Application for Planning Permission for Works or Extension to a Dwelling

Development: Rear Extension
Location: Brise De Mer Ham Manor Way Angmering BN16 4JQ

Project:	
Proposed extension; Brise de Mer, Ham Manor Way, Angmering BN16 4JQ	
Drawing:	
Plans and elevations as existing	
For:	
Mr. & Mrs. C. McGowan	
Drawn:	Date:
PKS	July 2026
Scales:	No:
1:1001:200	3476/01/01
To scale when printed on A3

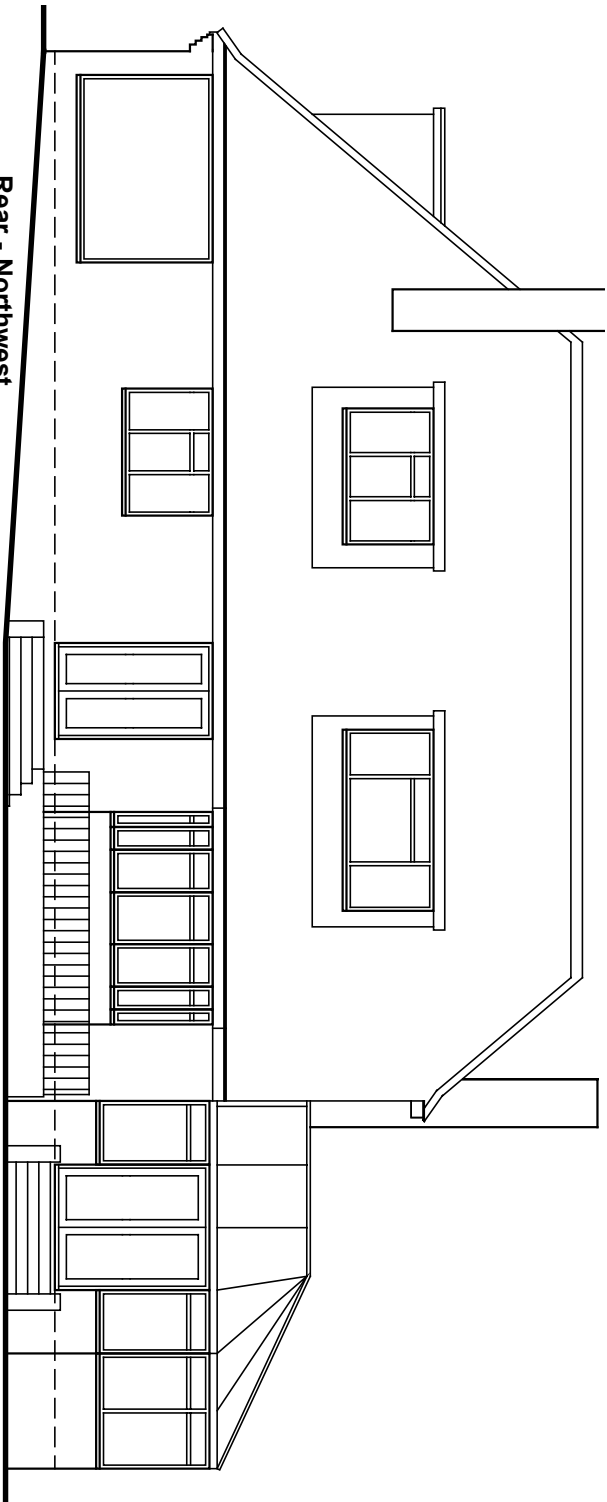
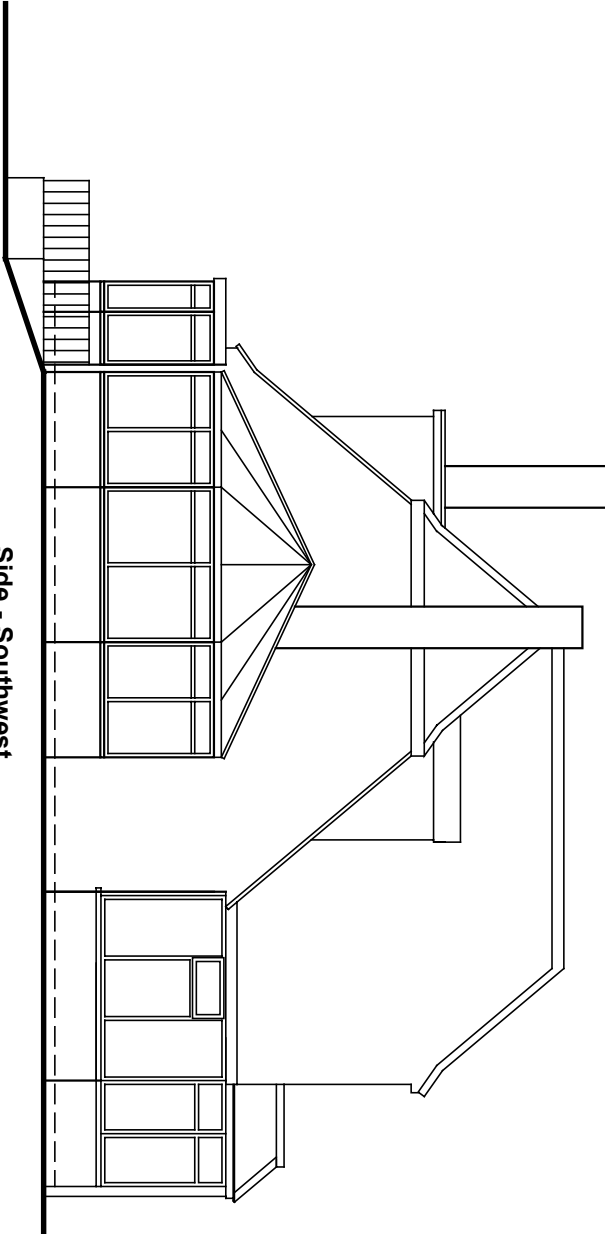
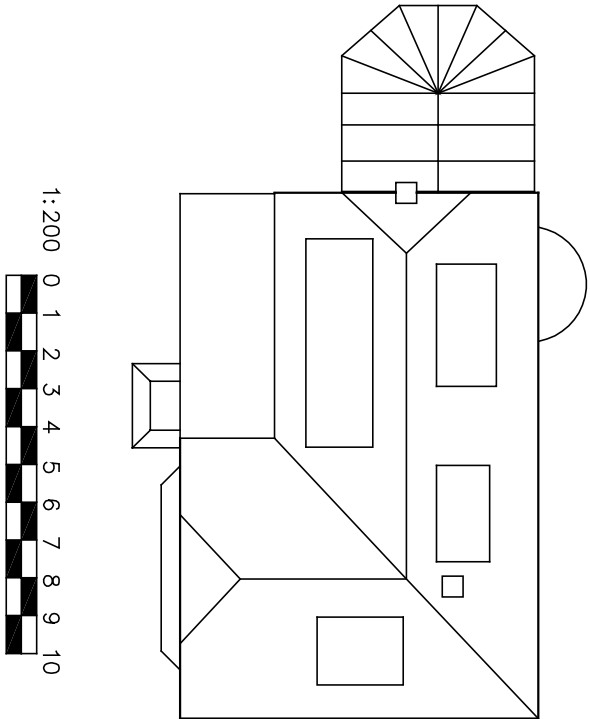
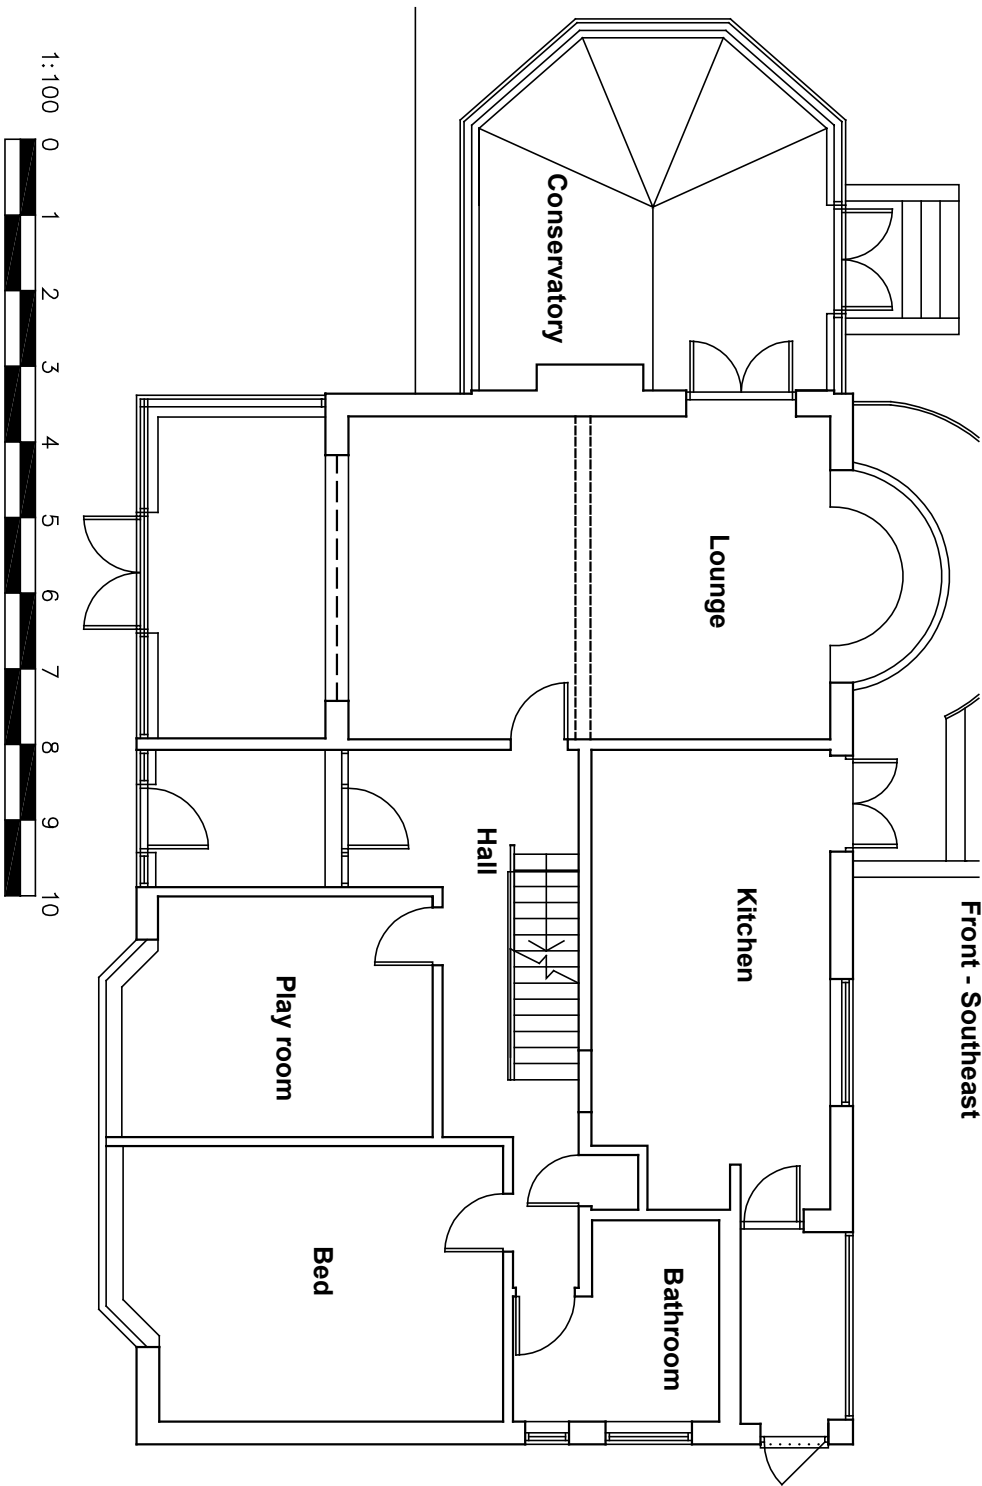
The existing and proposed lounge bay window and playroom bay window both needs to be drawn the same as the other windows for consistency.

Side - Southwest

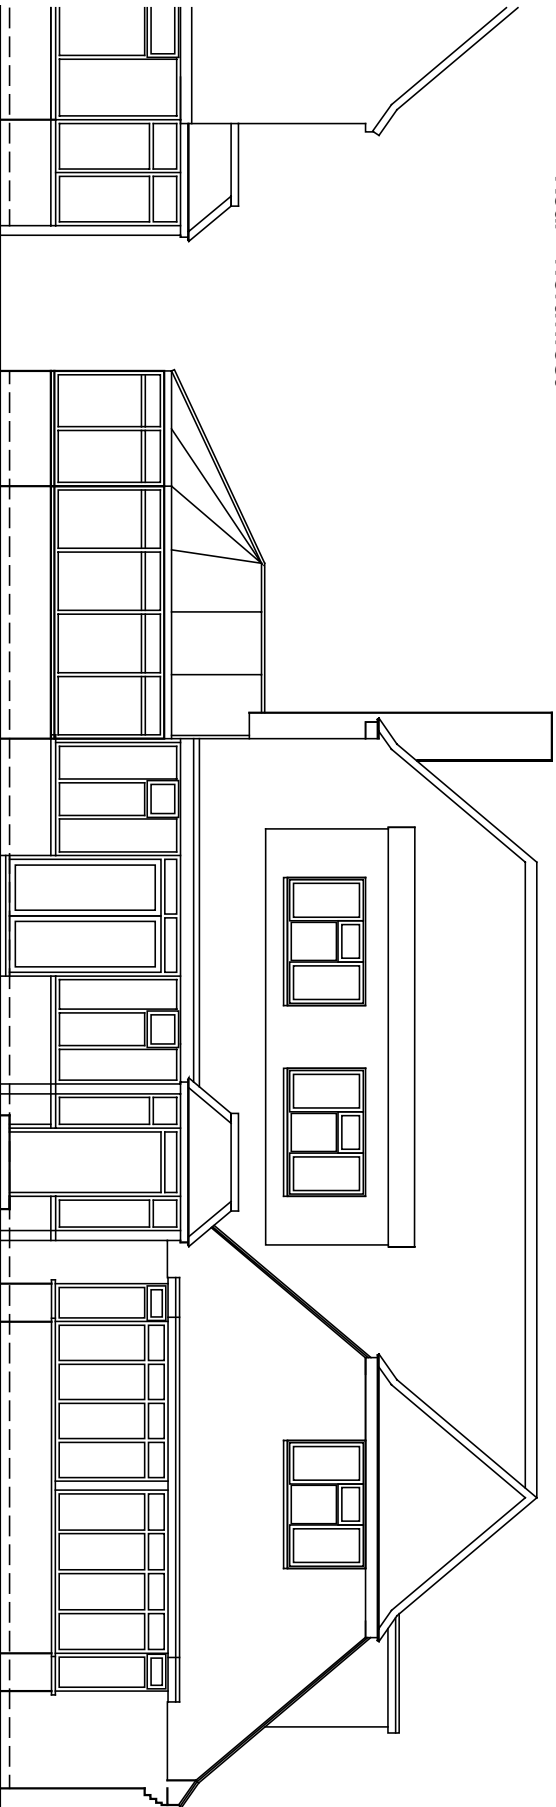
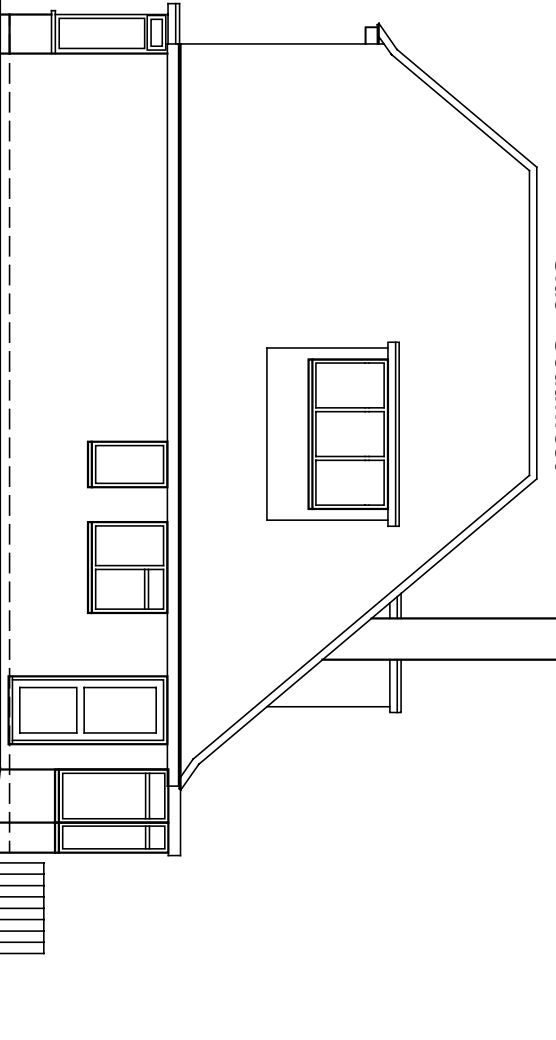
The southwest existing and proposed elevation plan is not consistent with the floor plans.

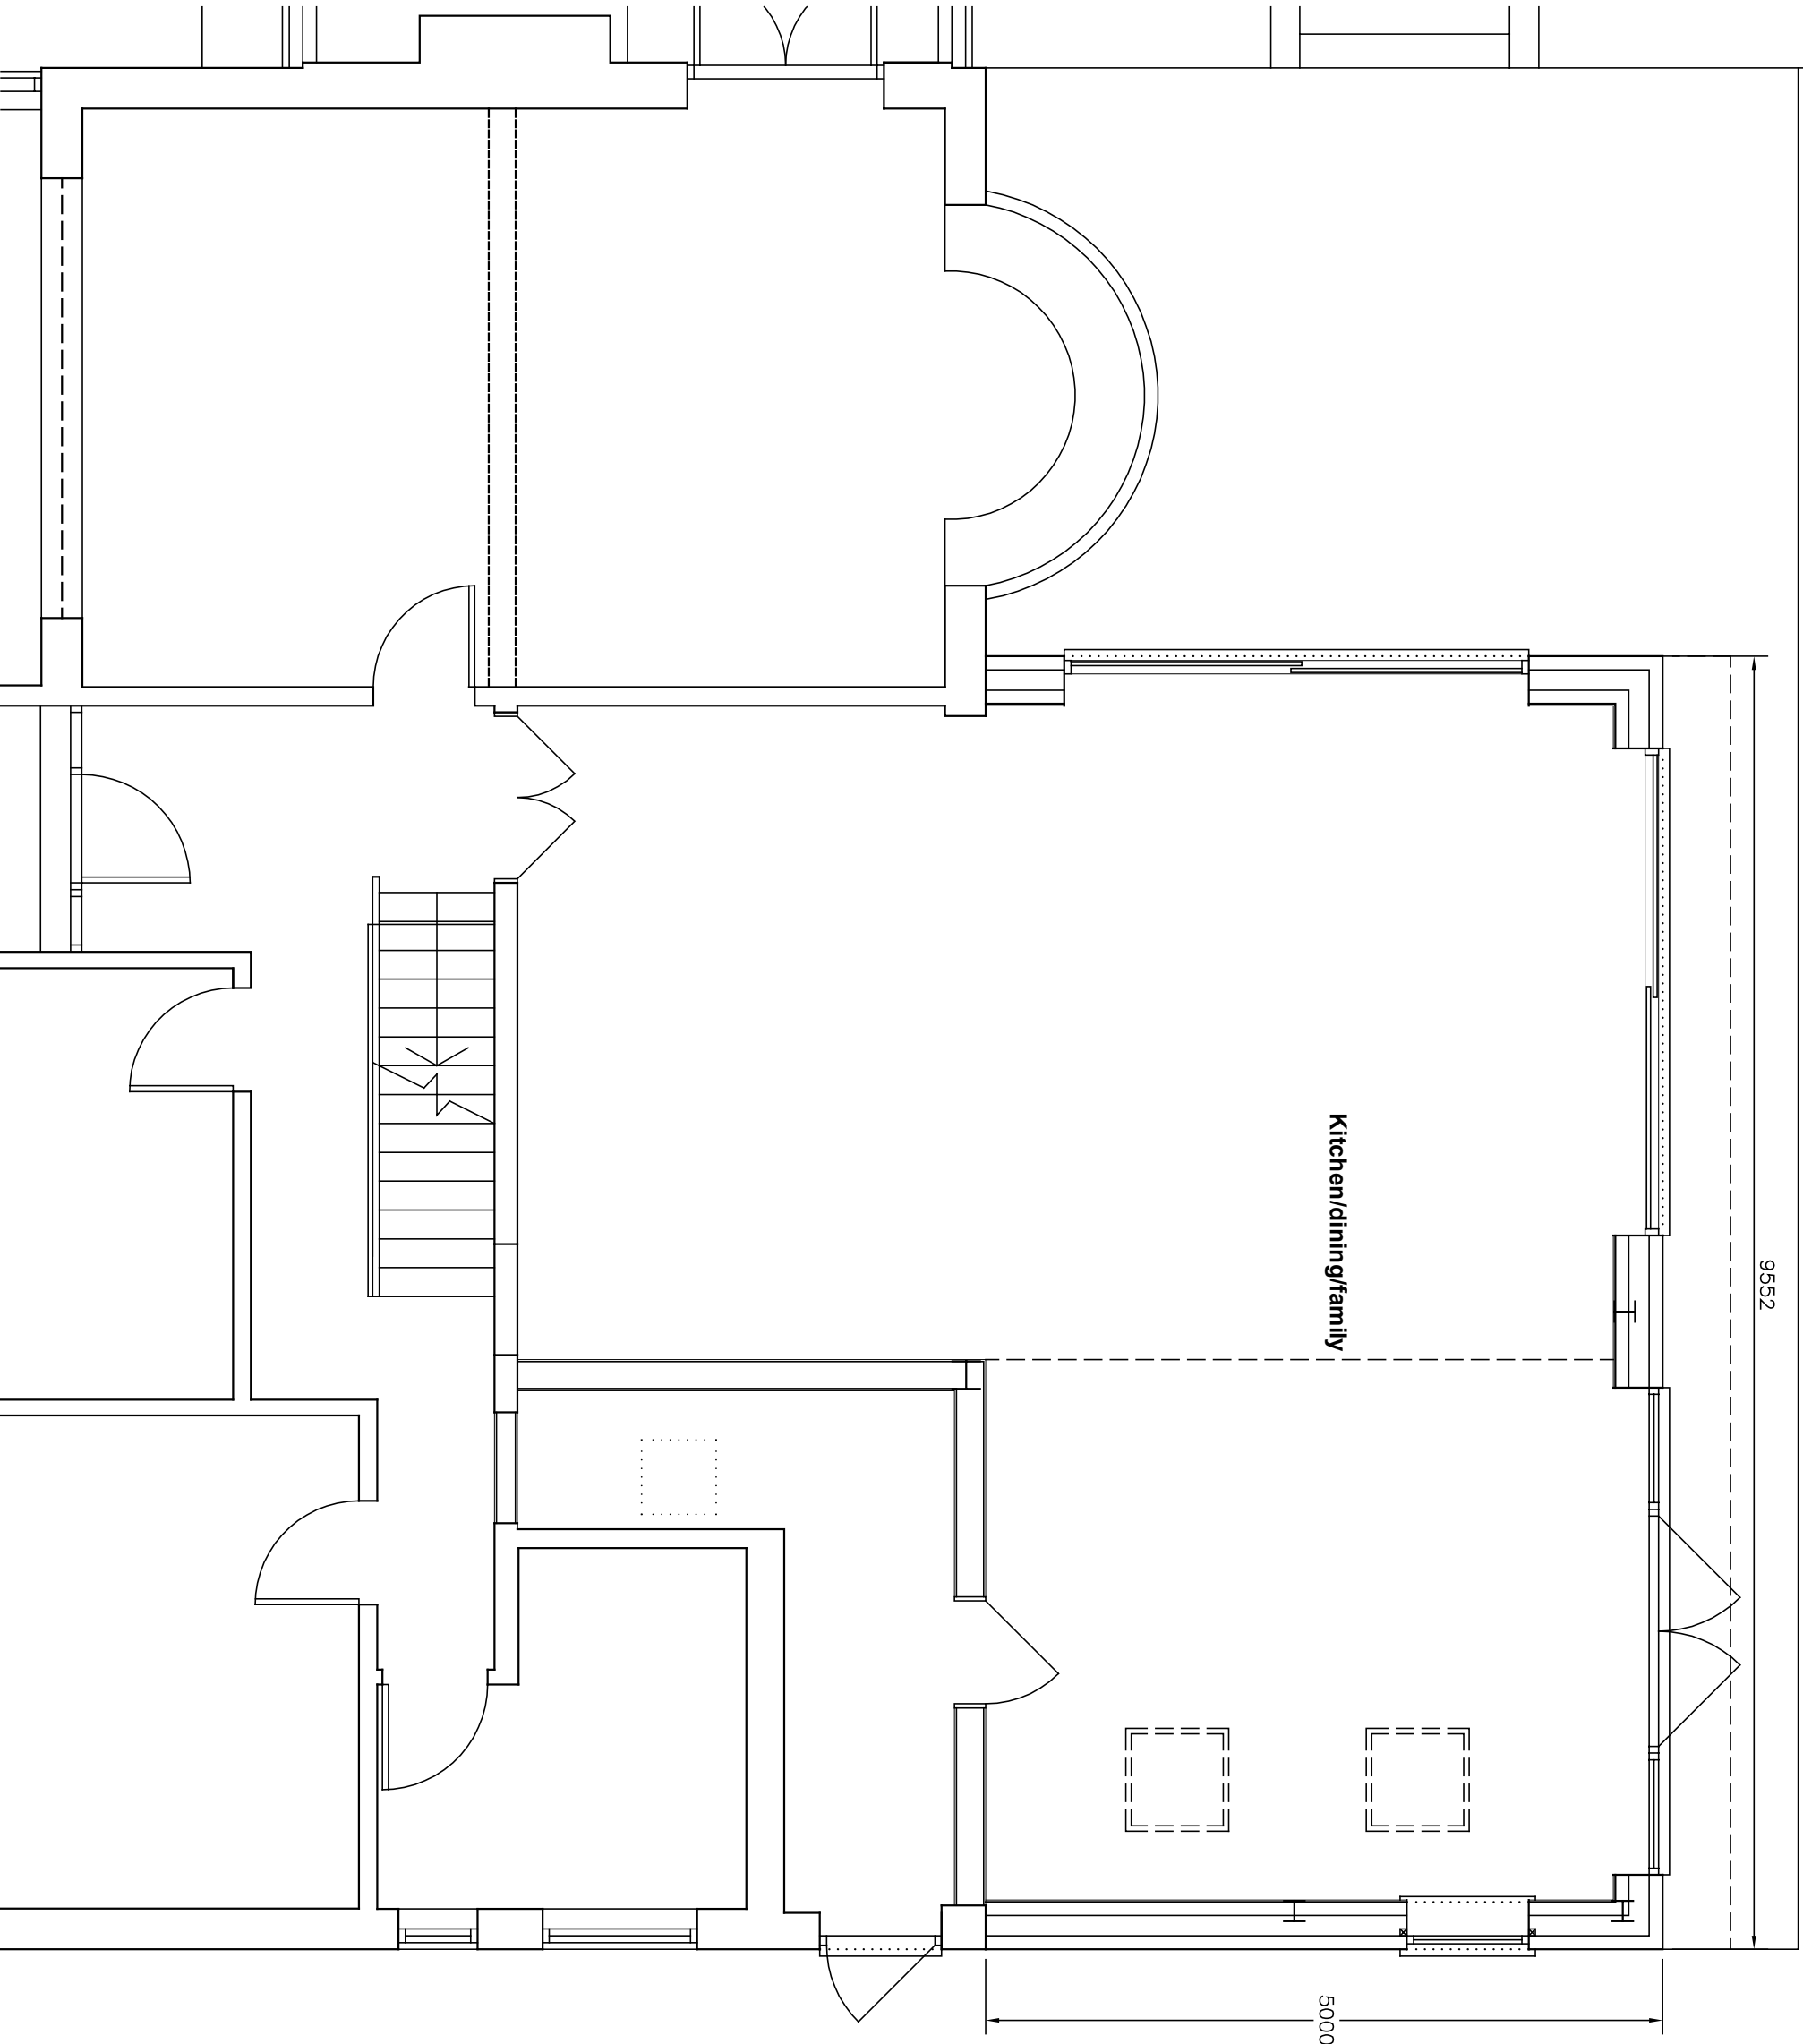
The dimensions of the proposed works on the block plan are inconsistent with the dimensions of the proposed works on the proposed floor/elevation plans.
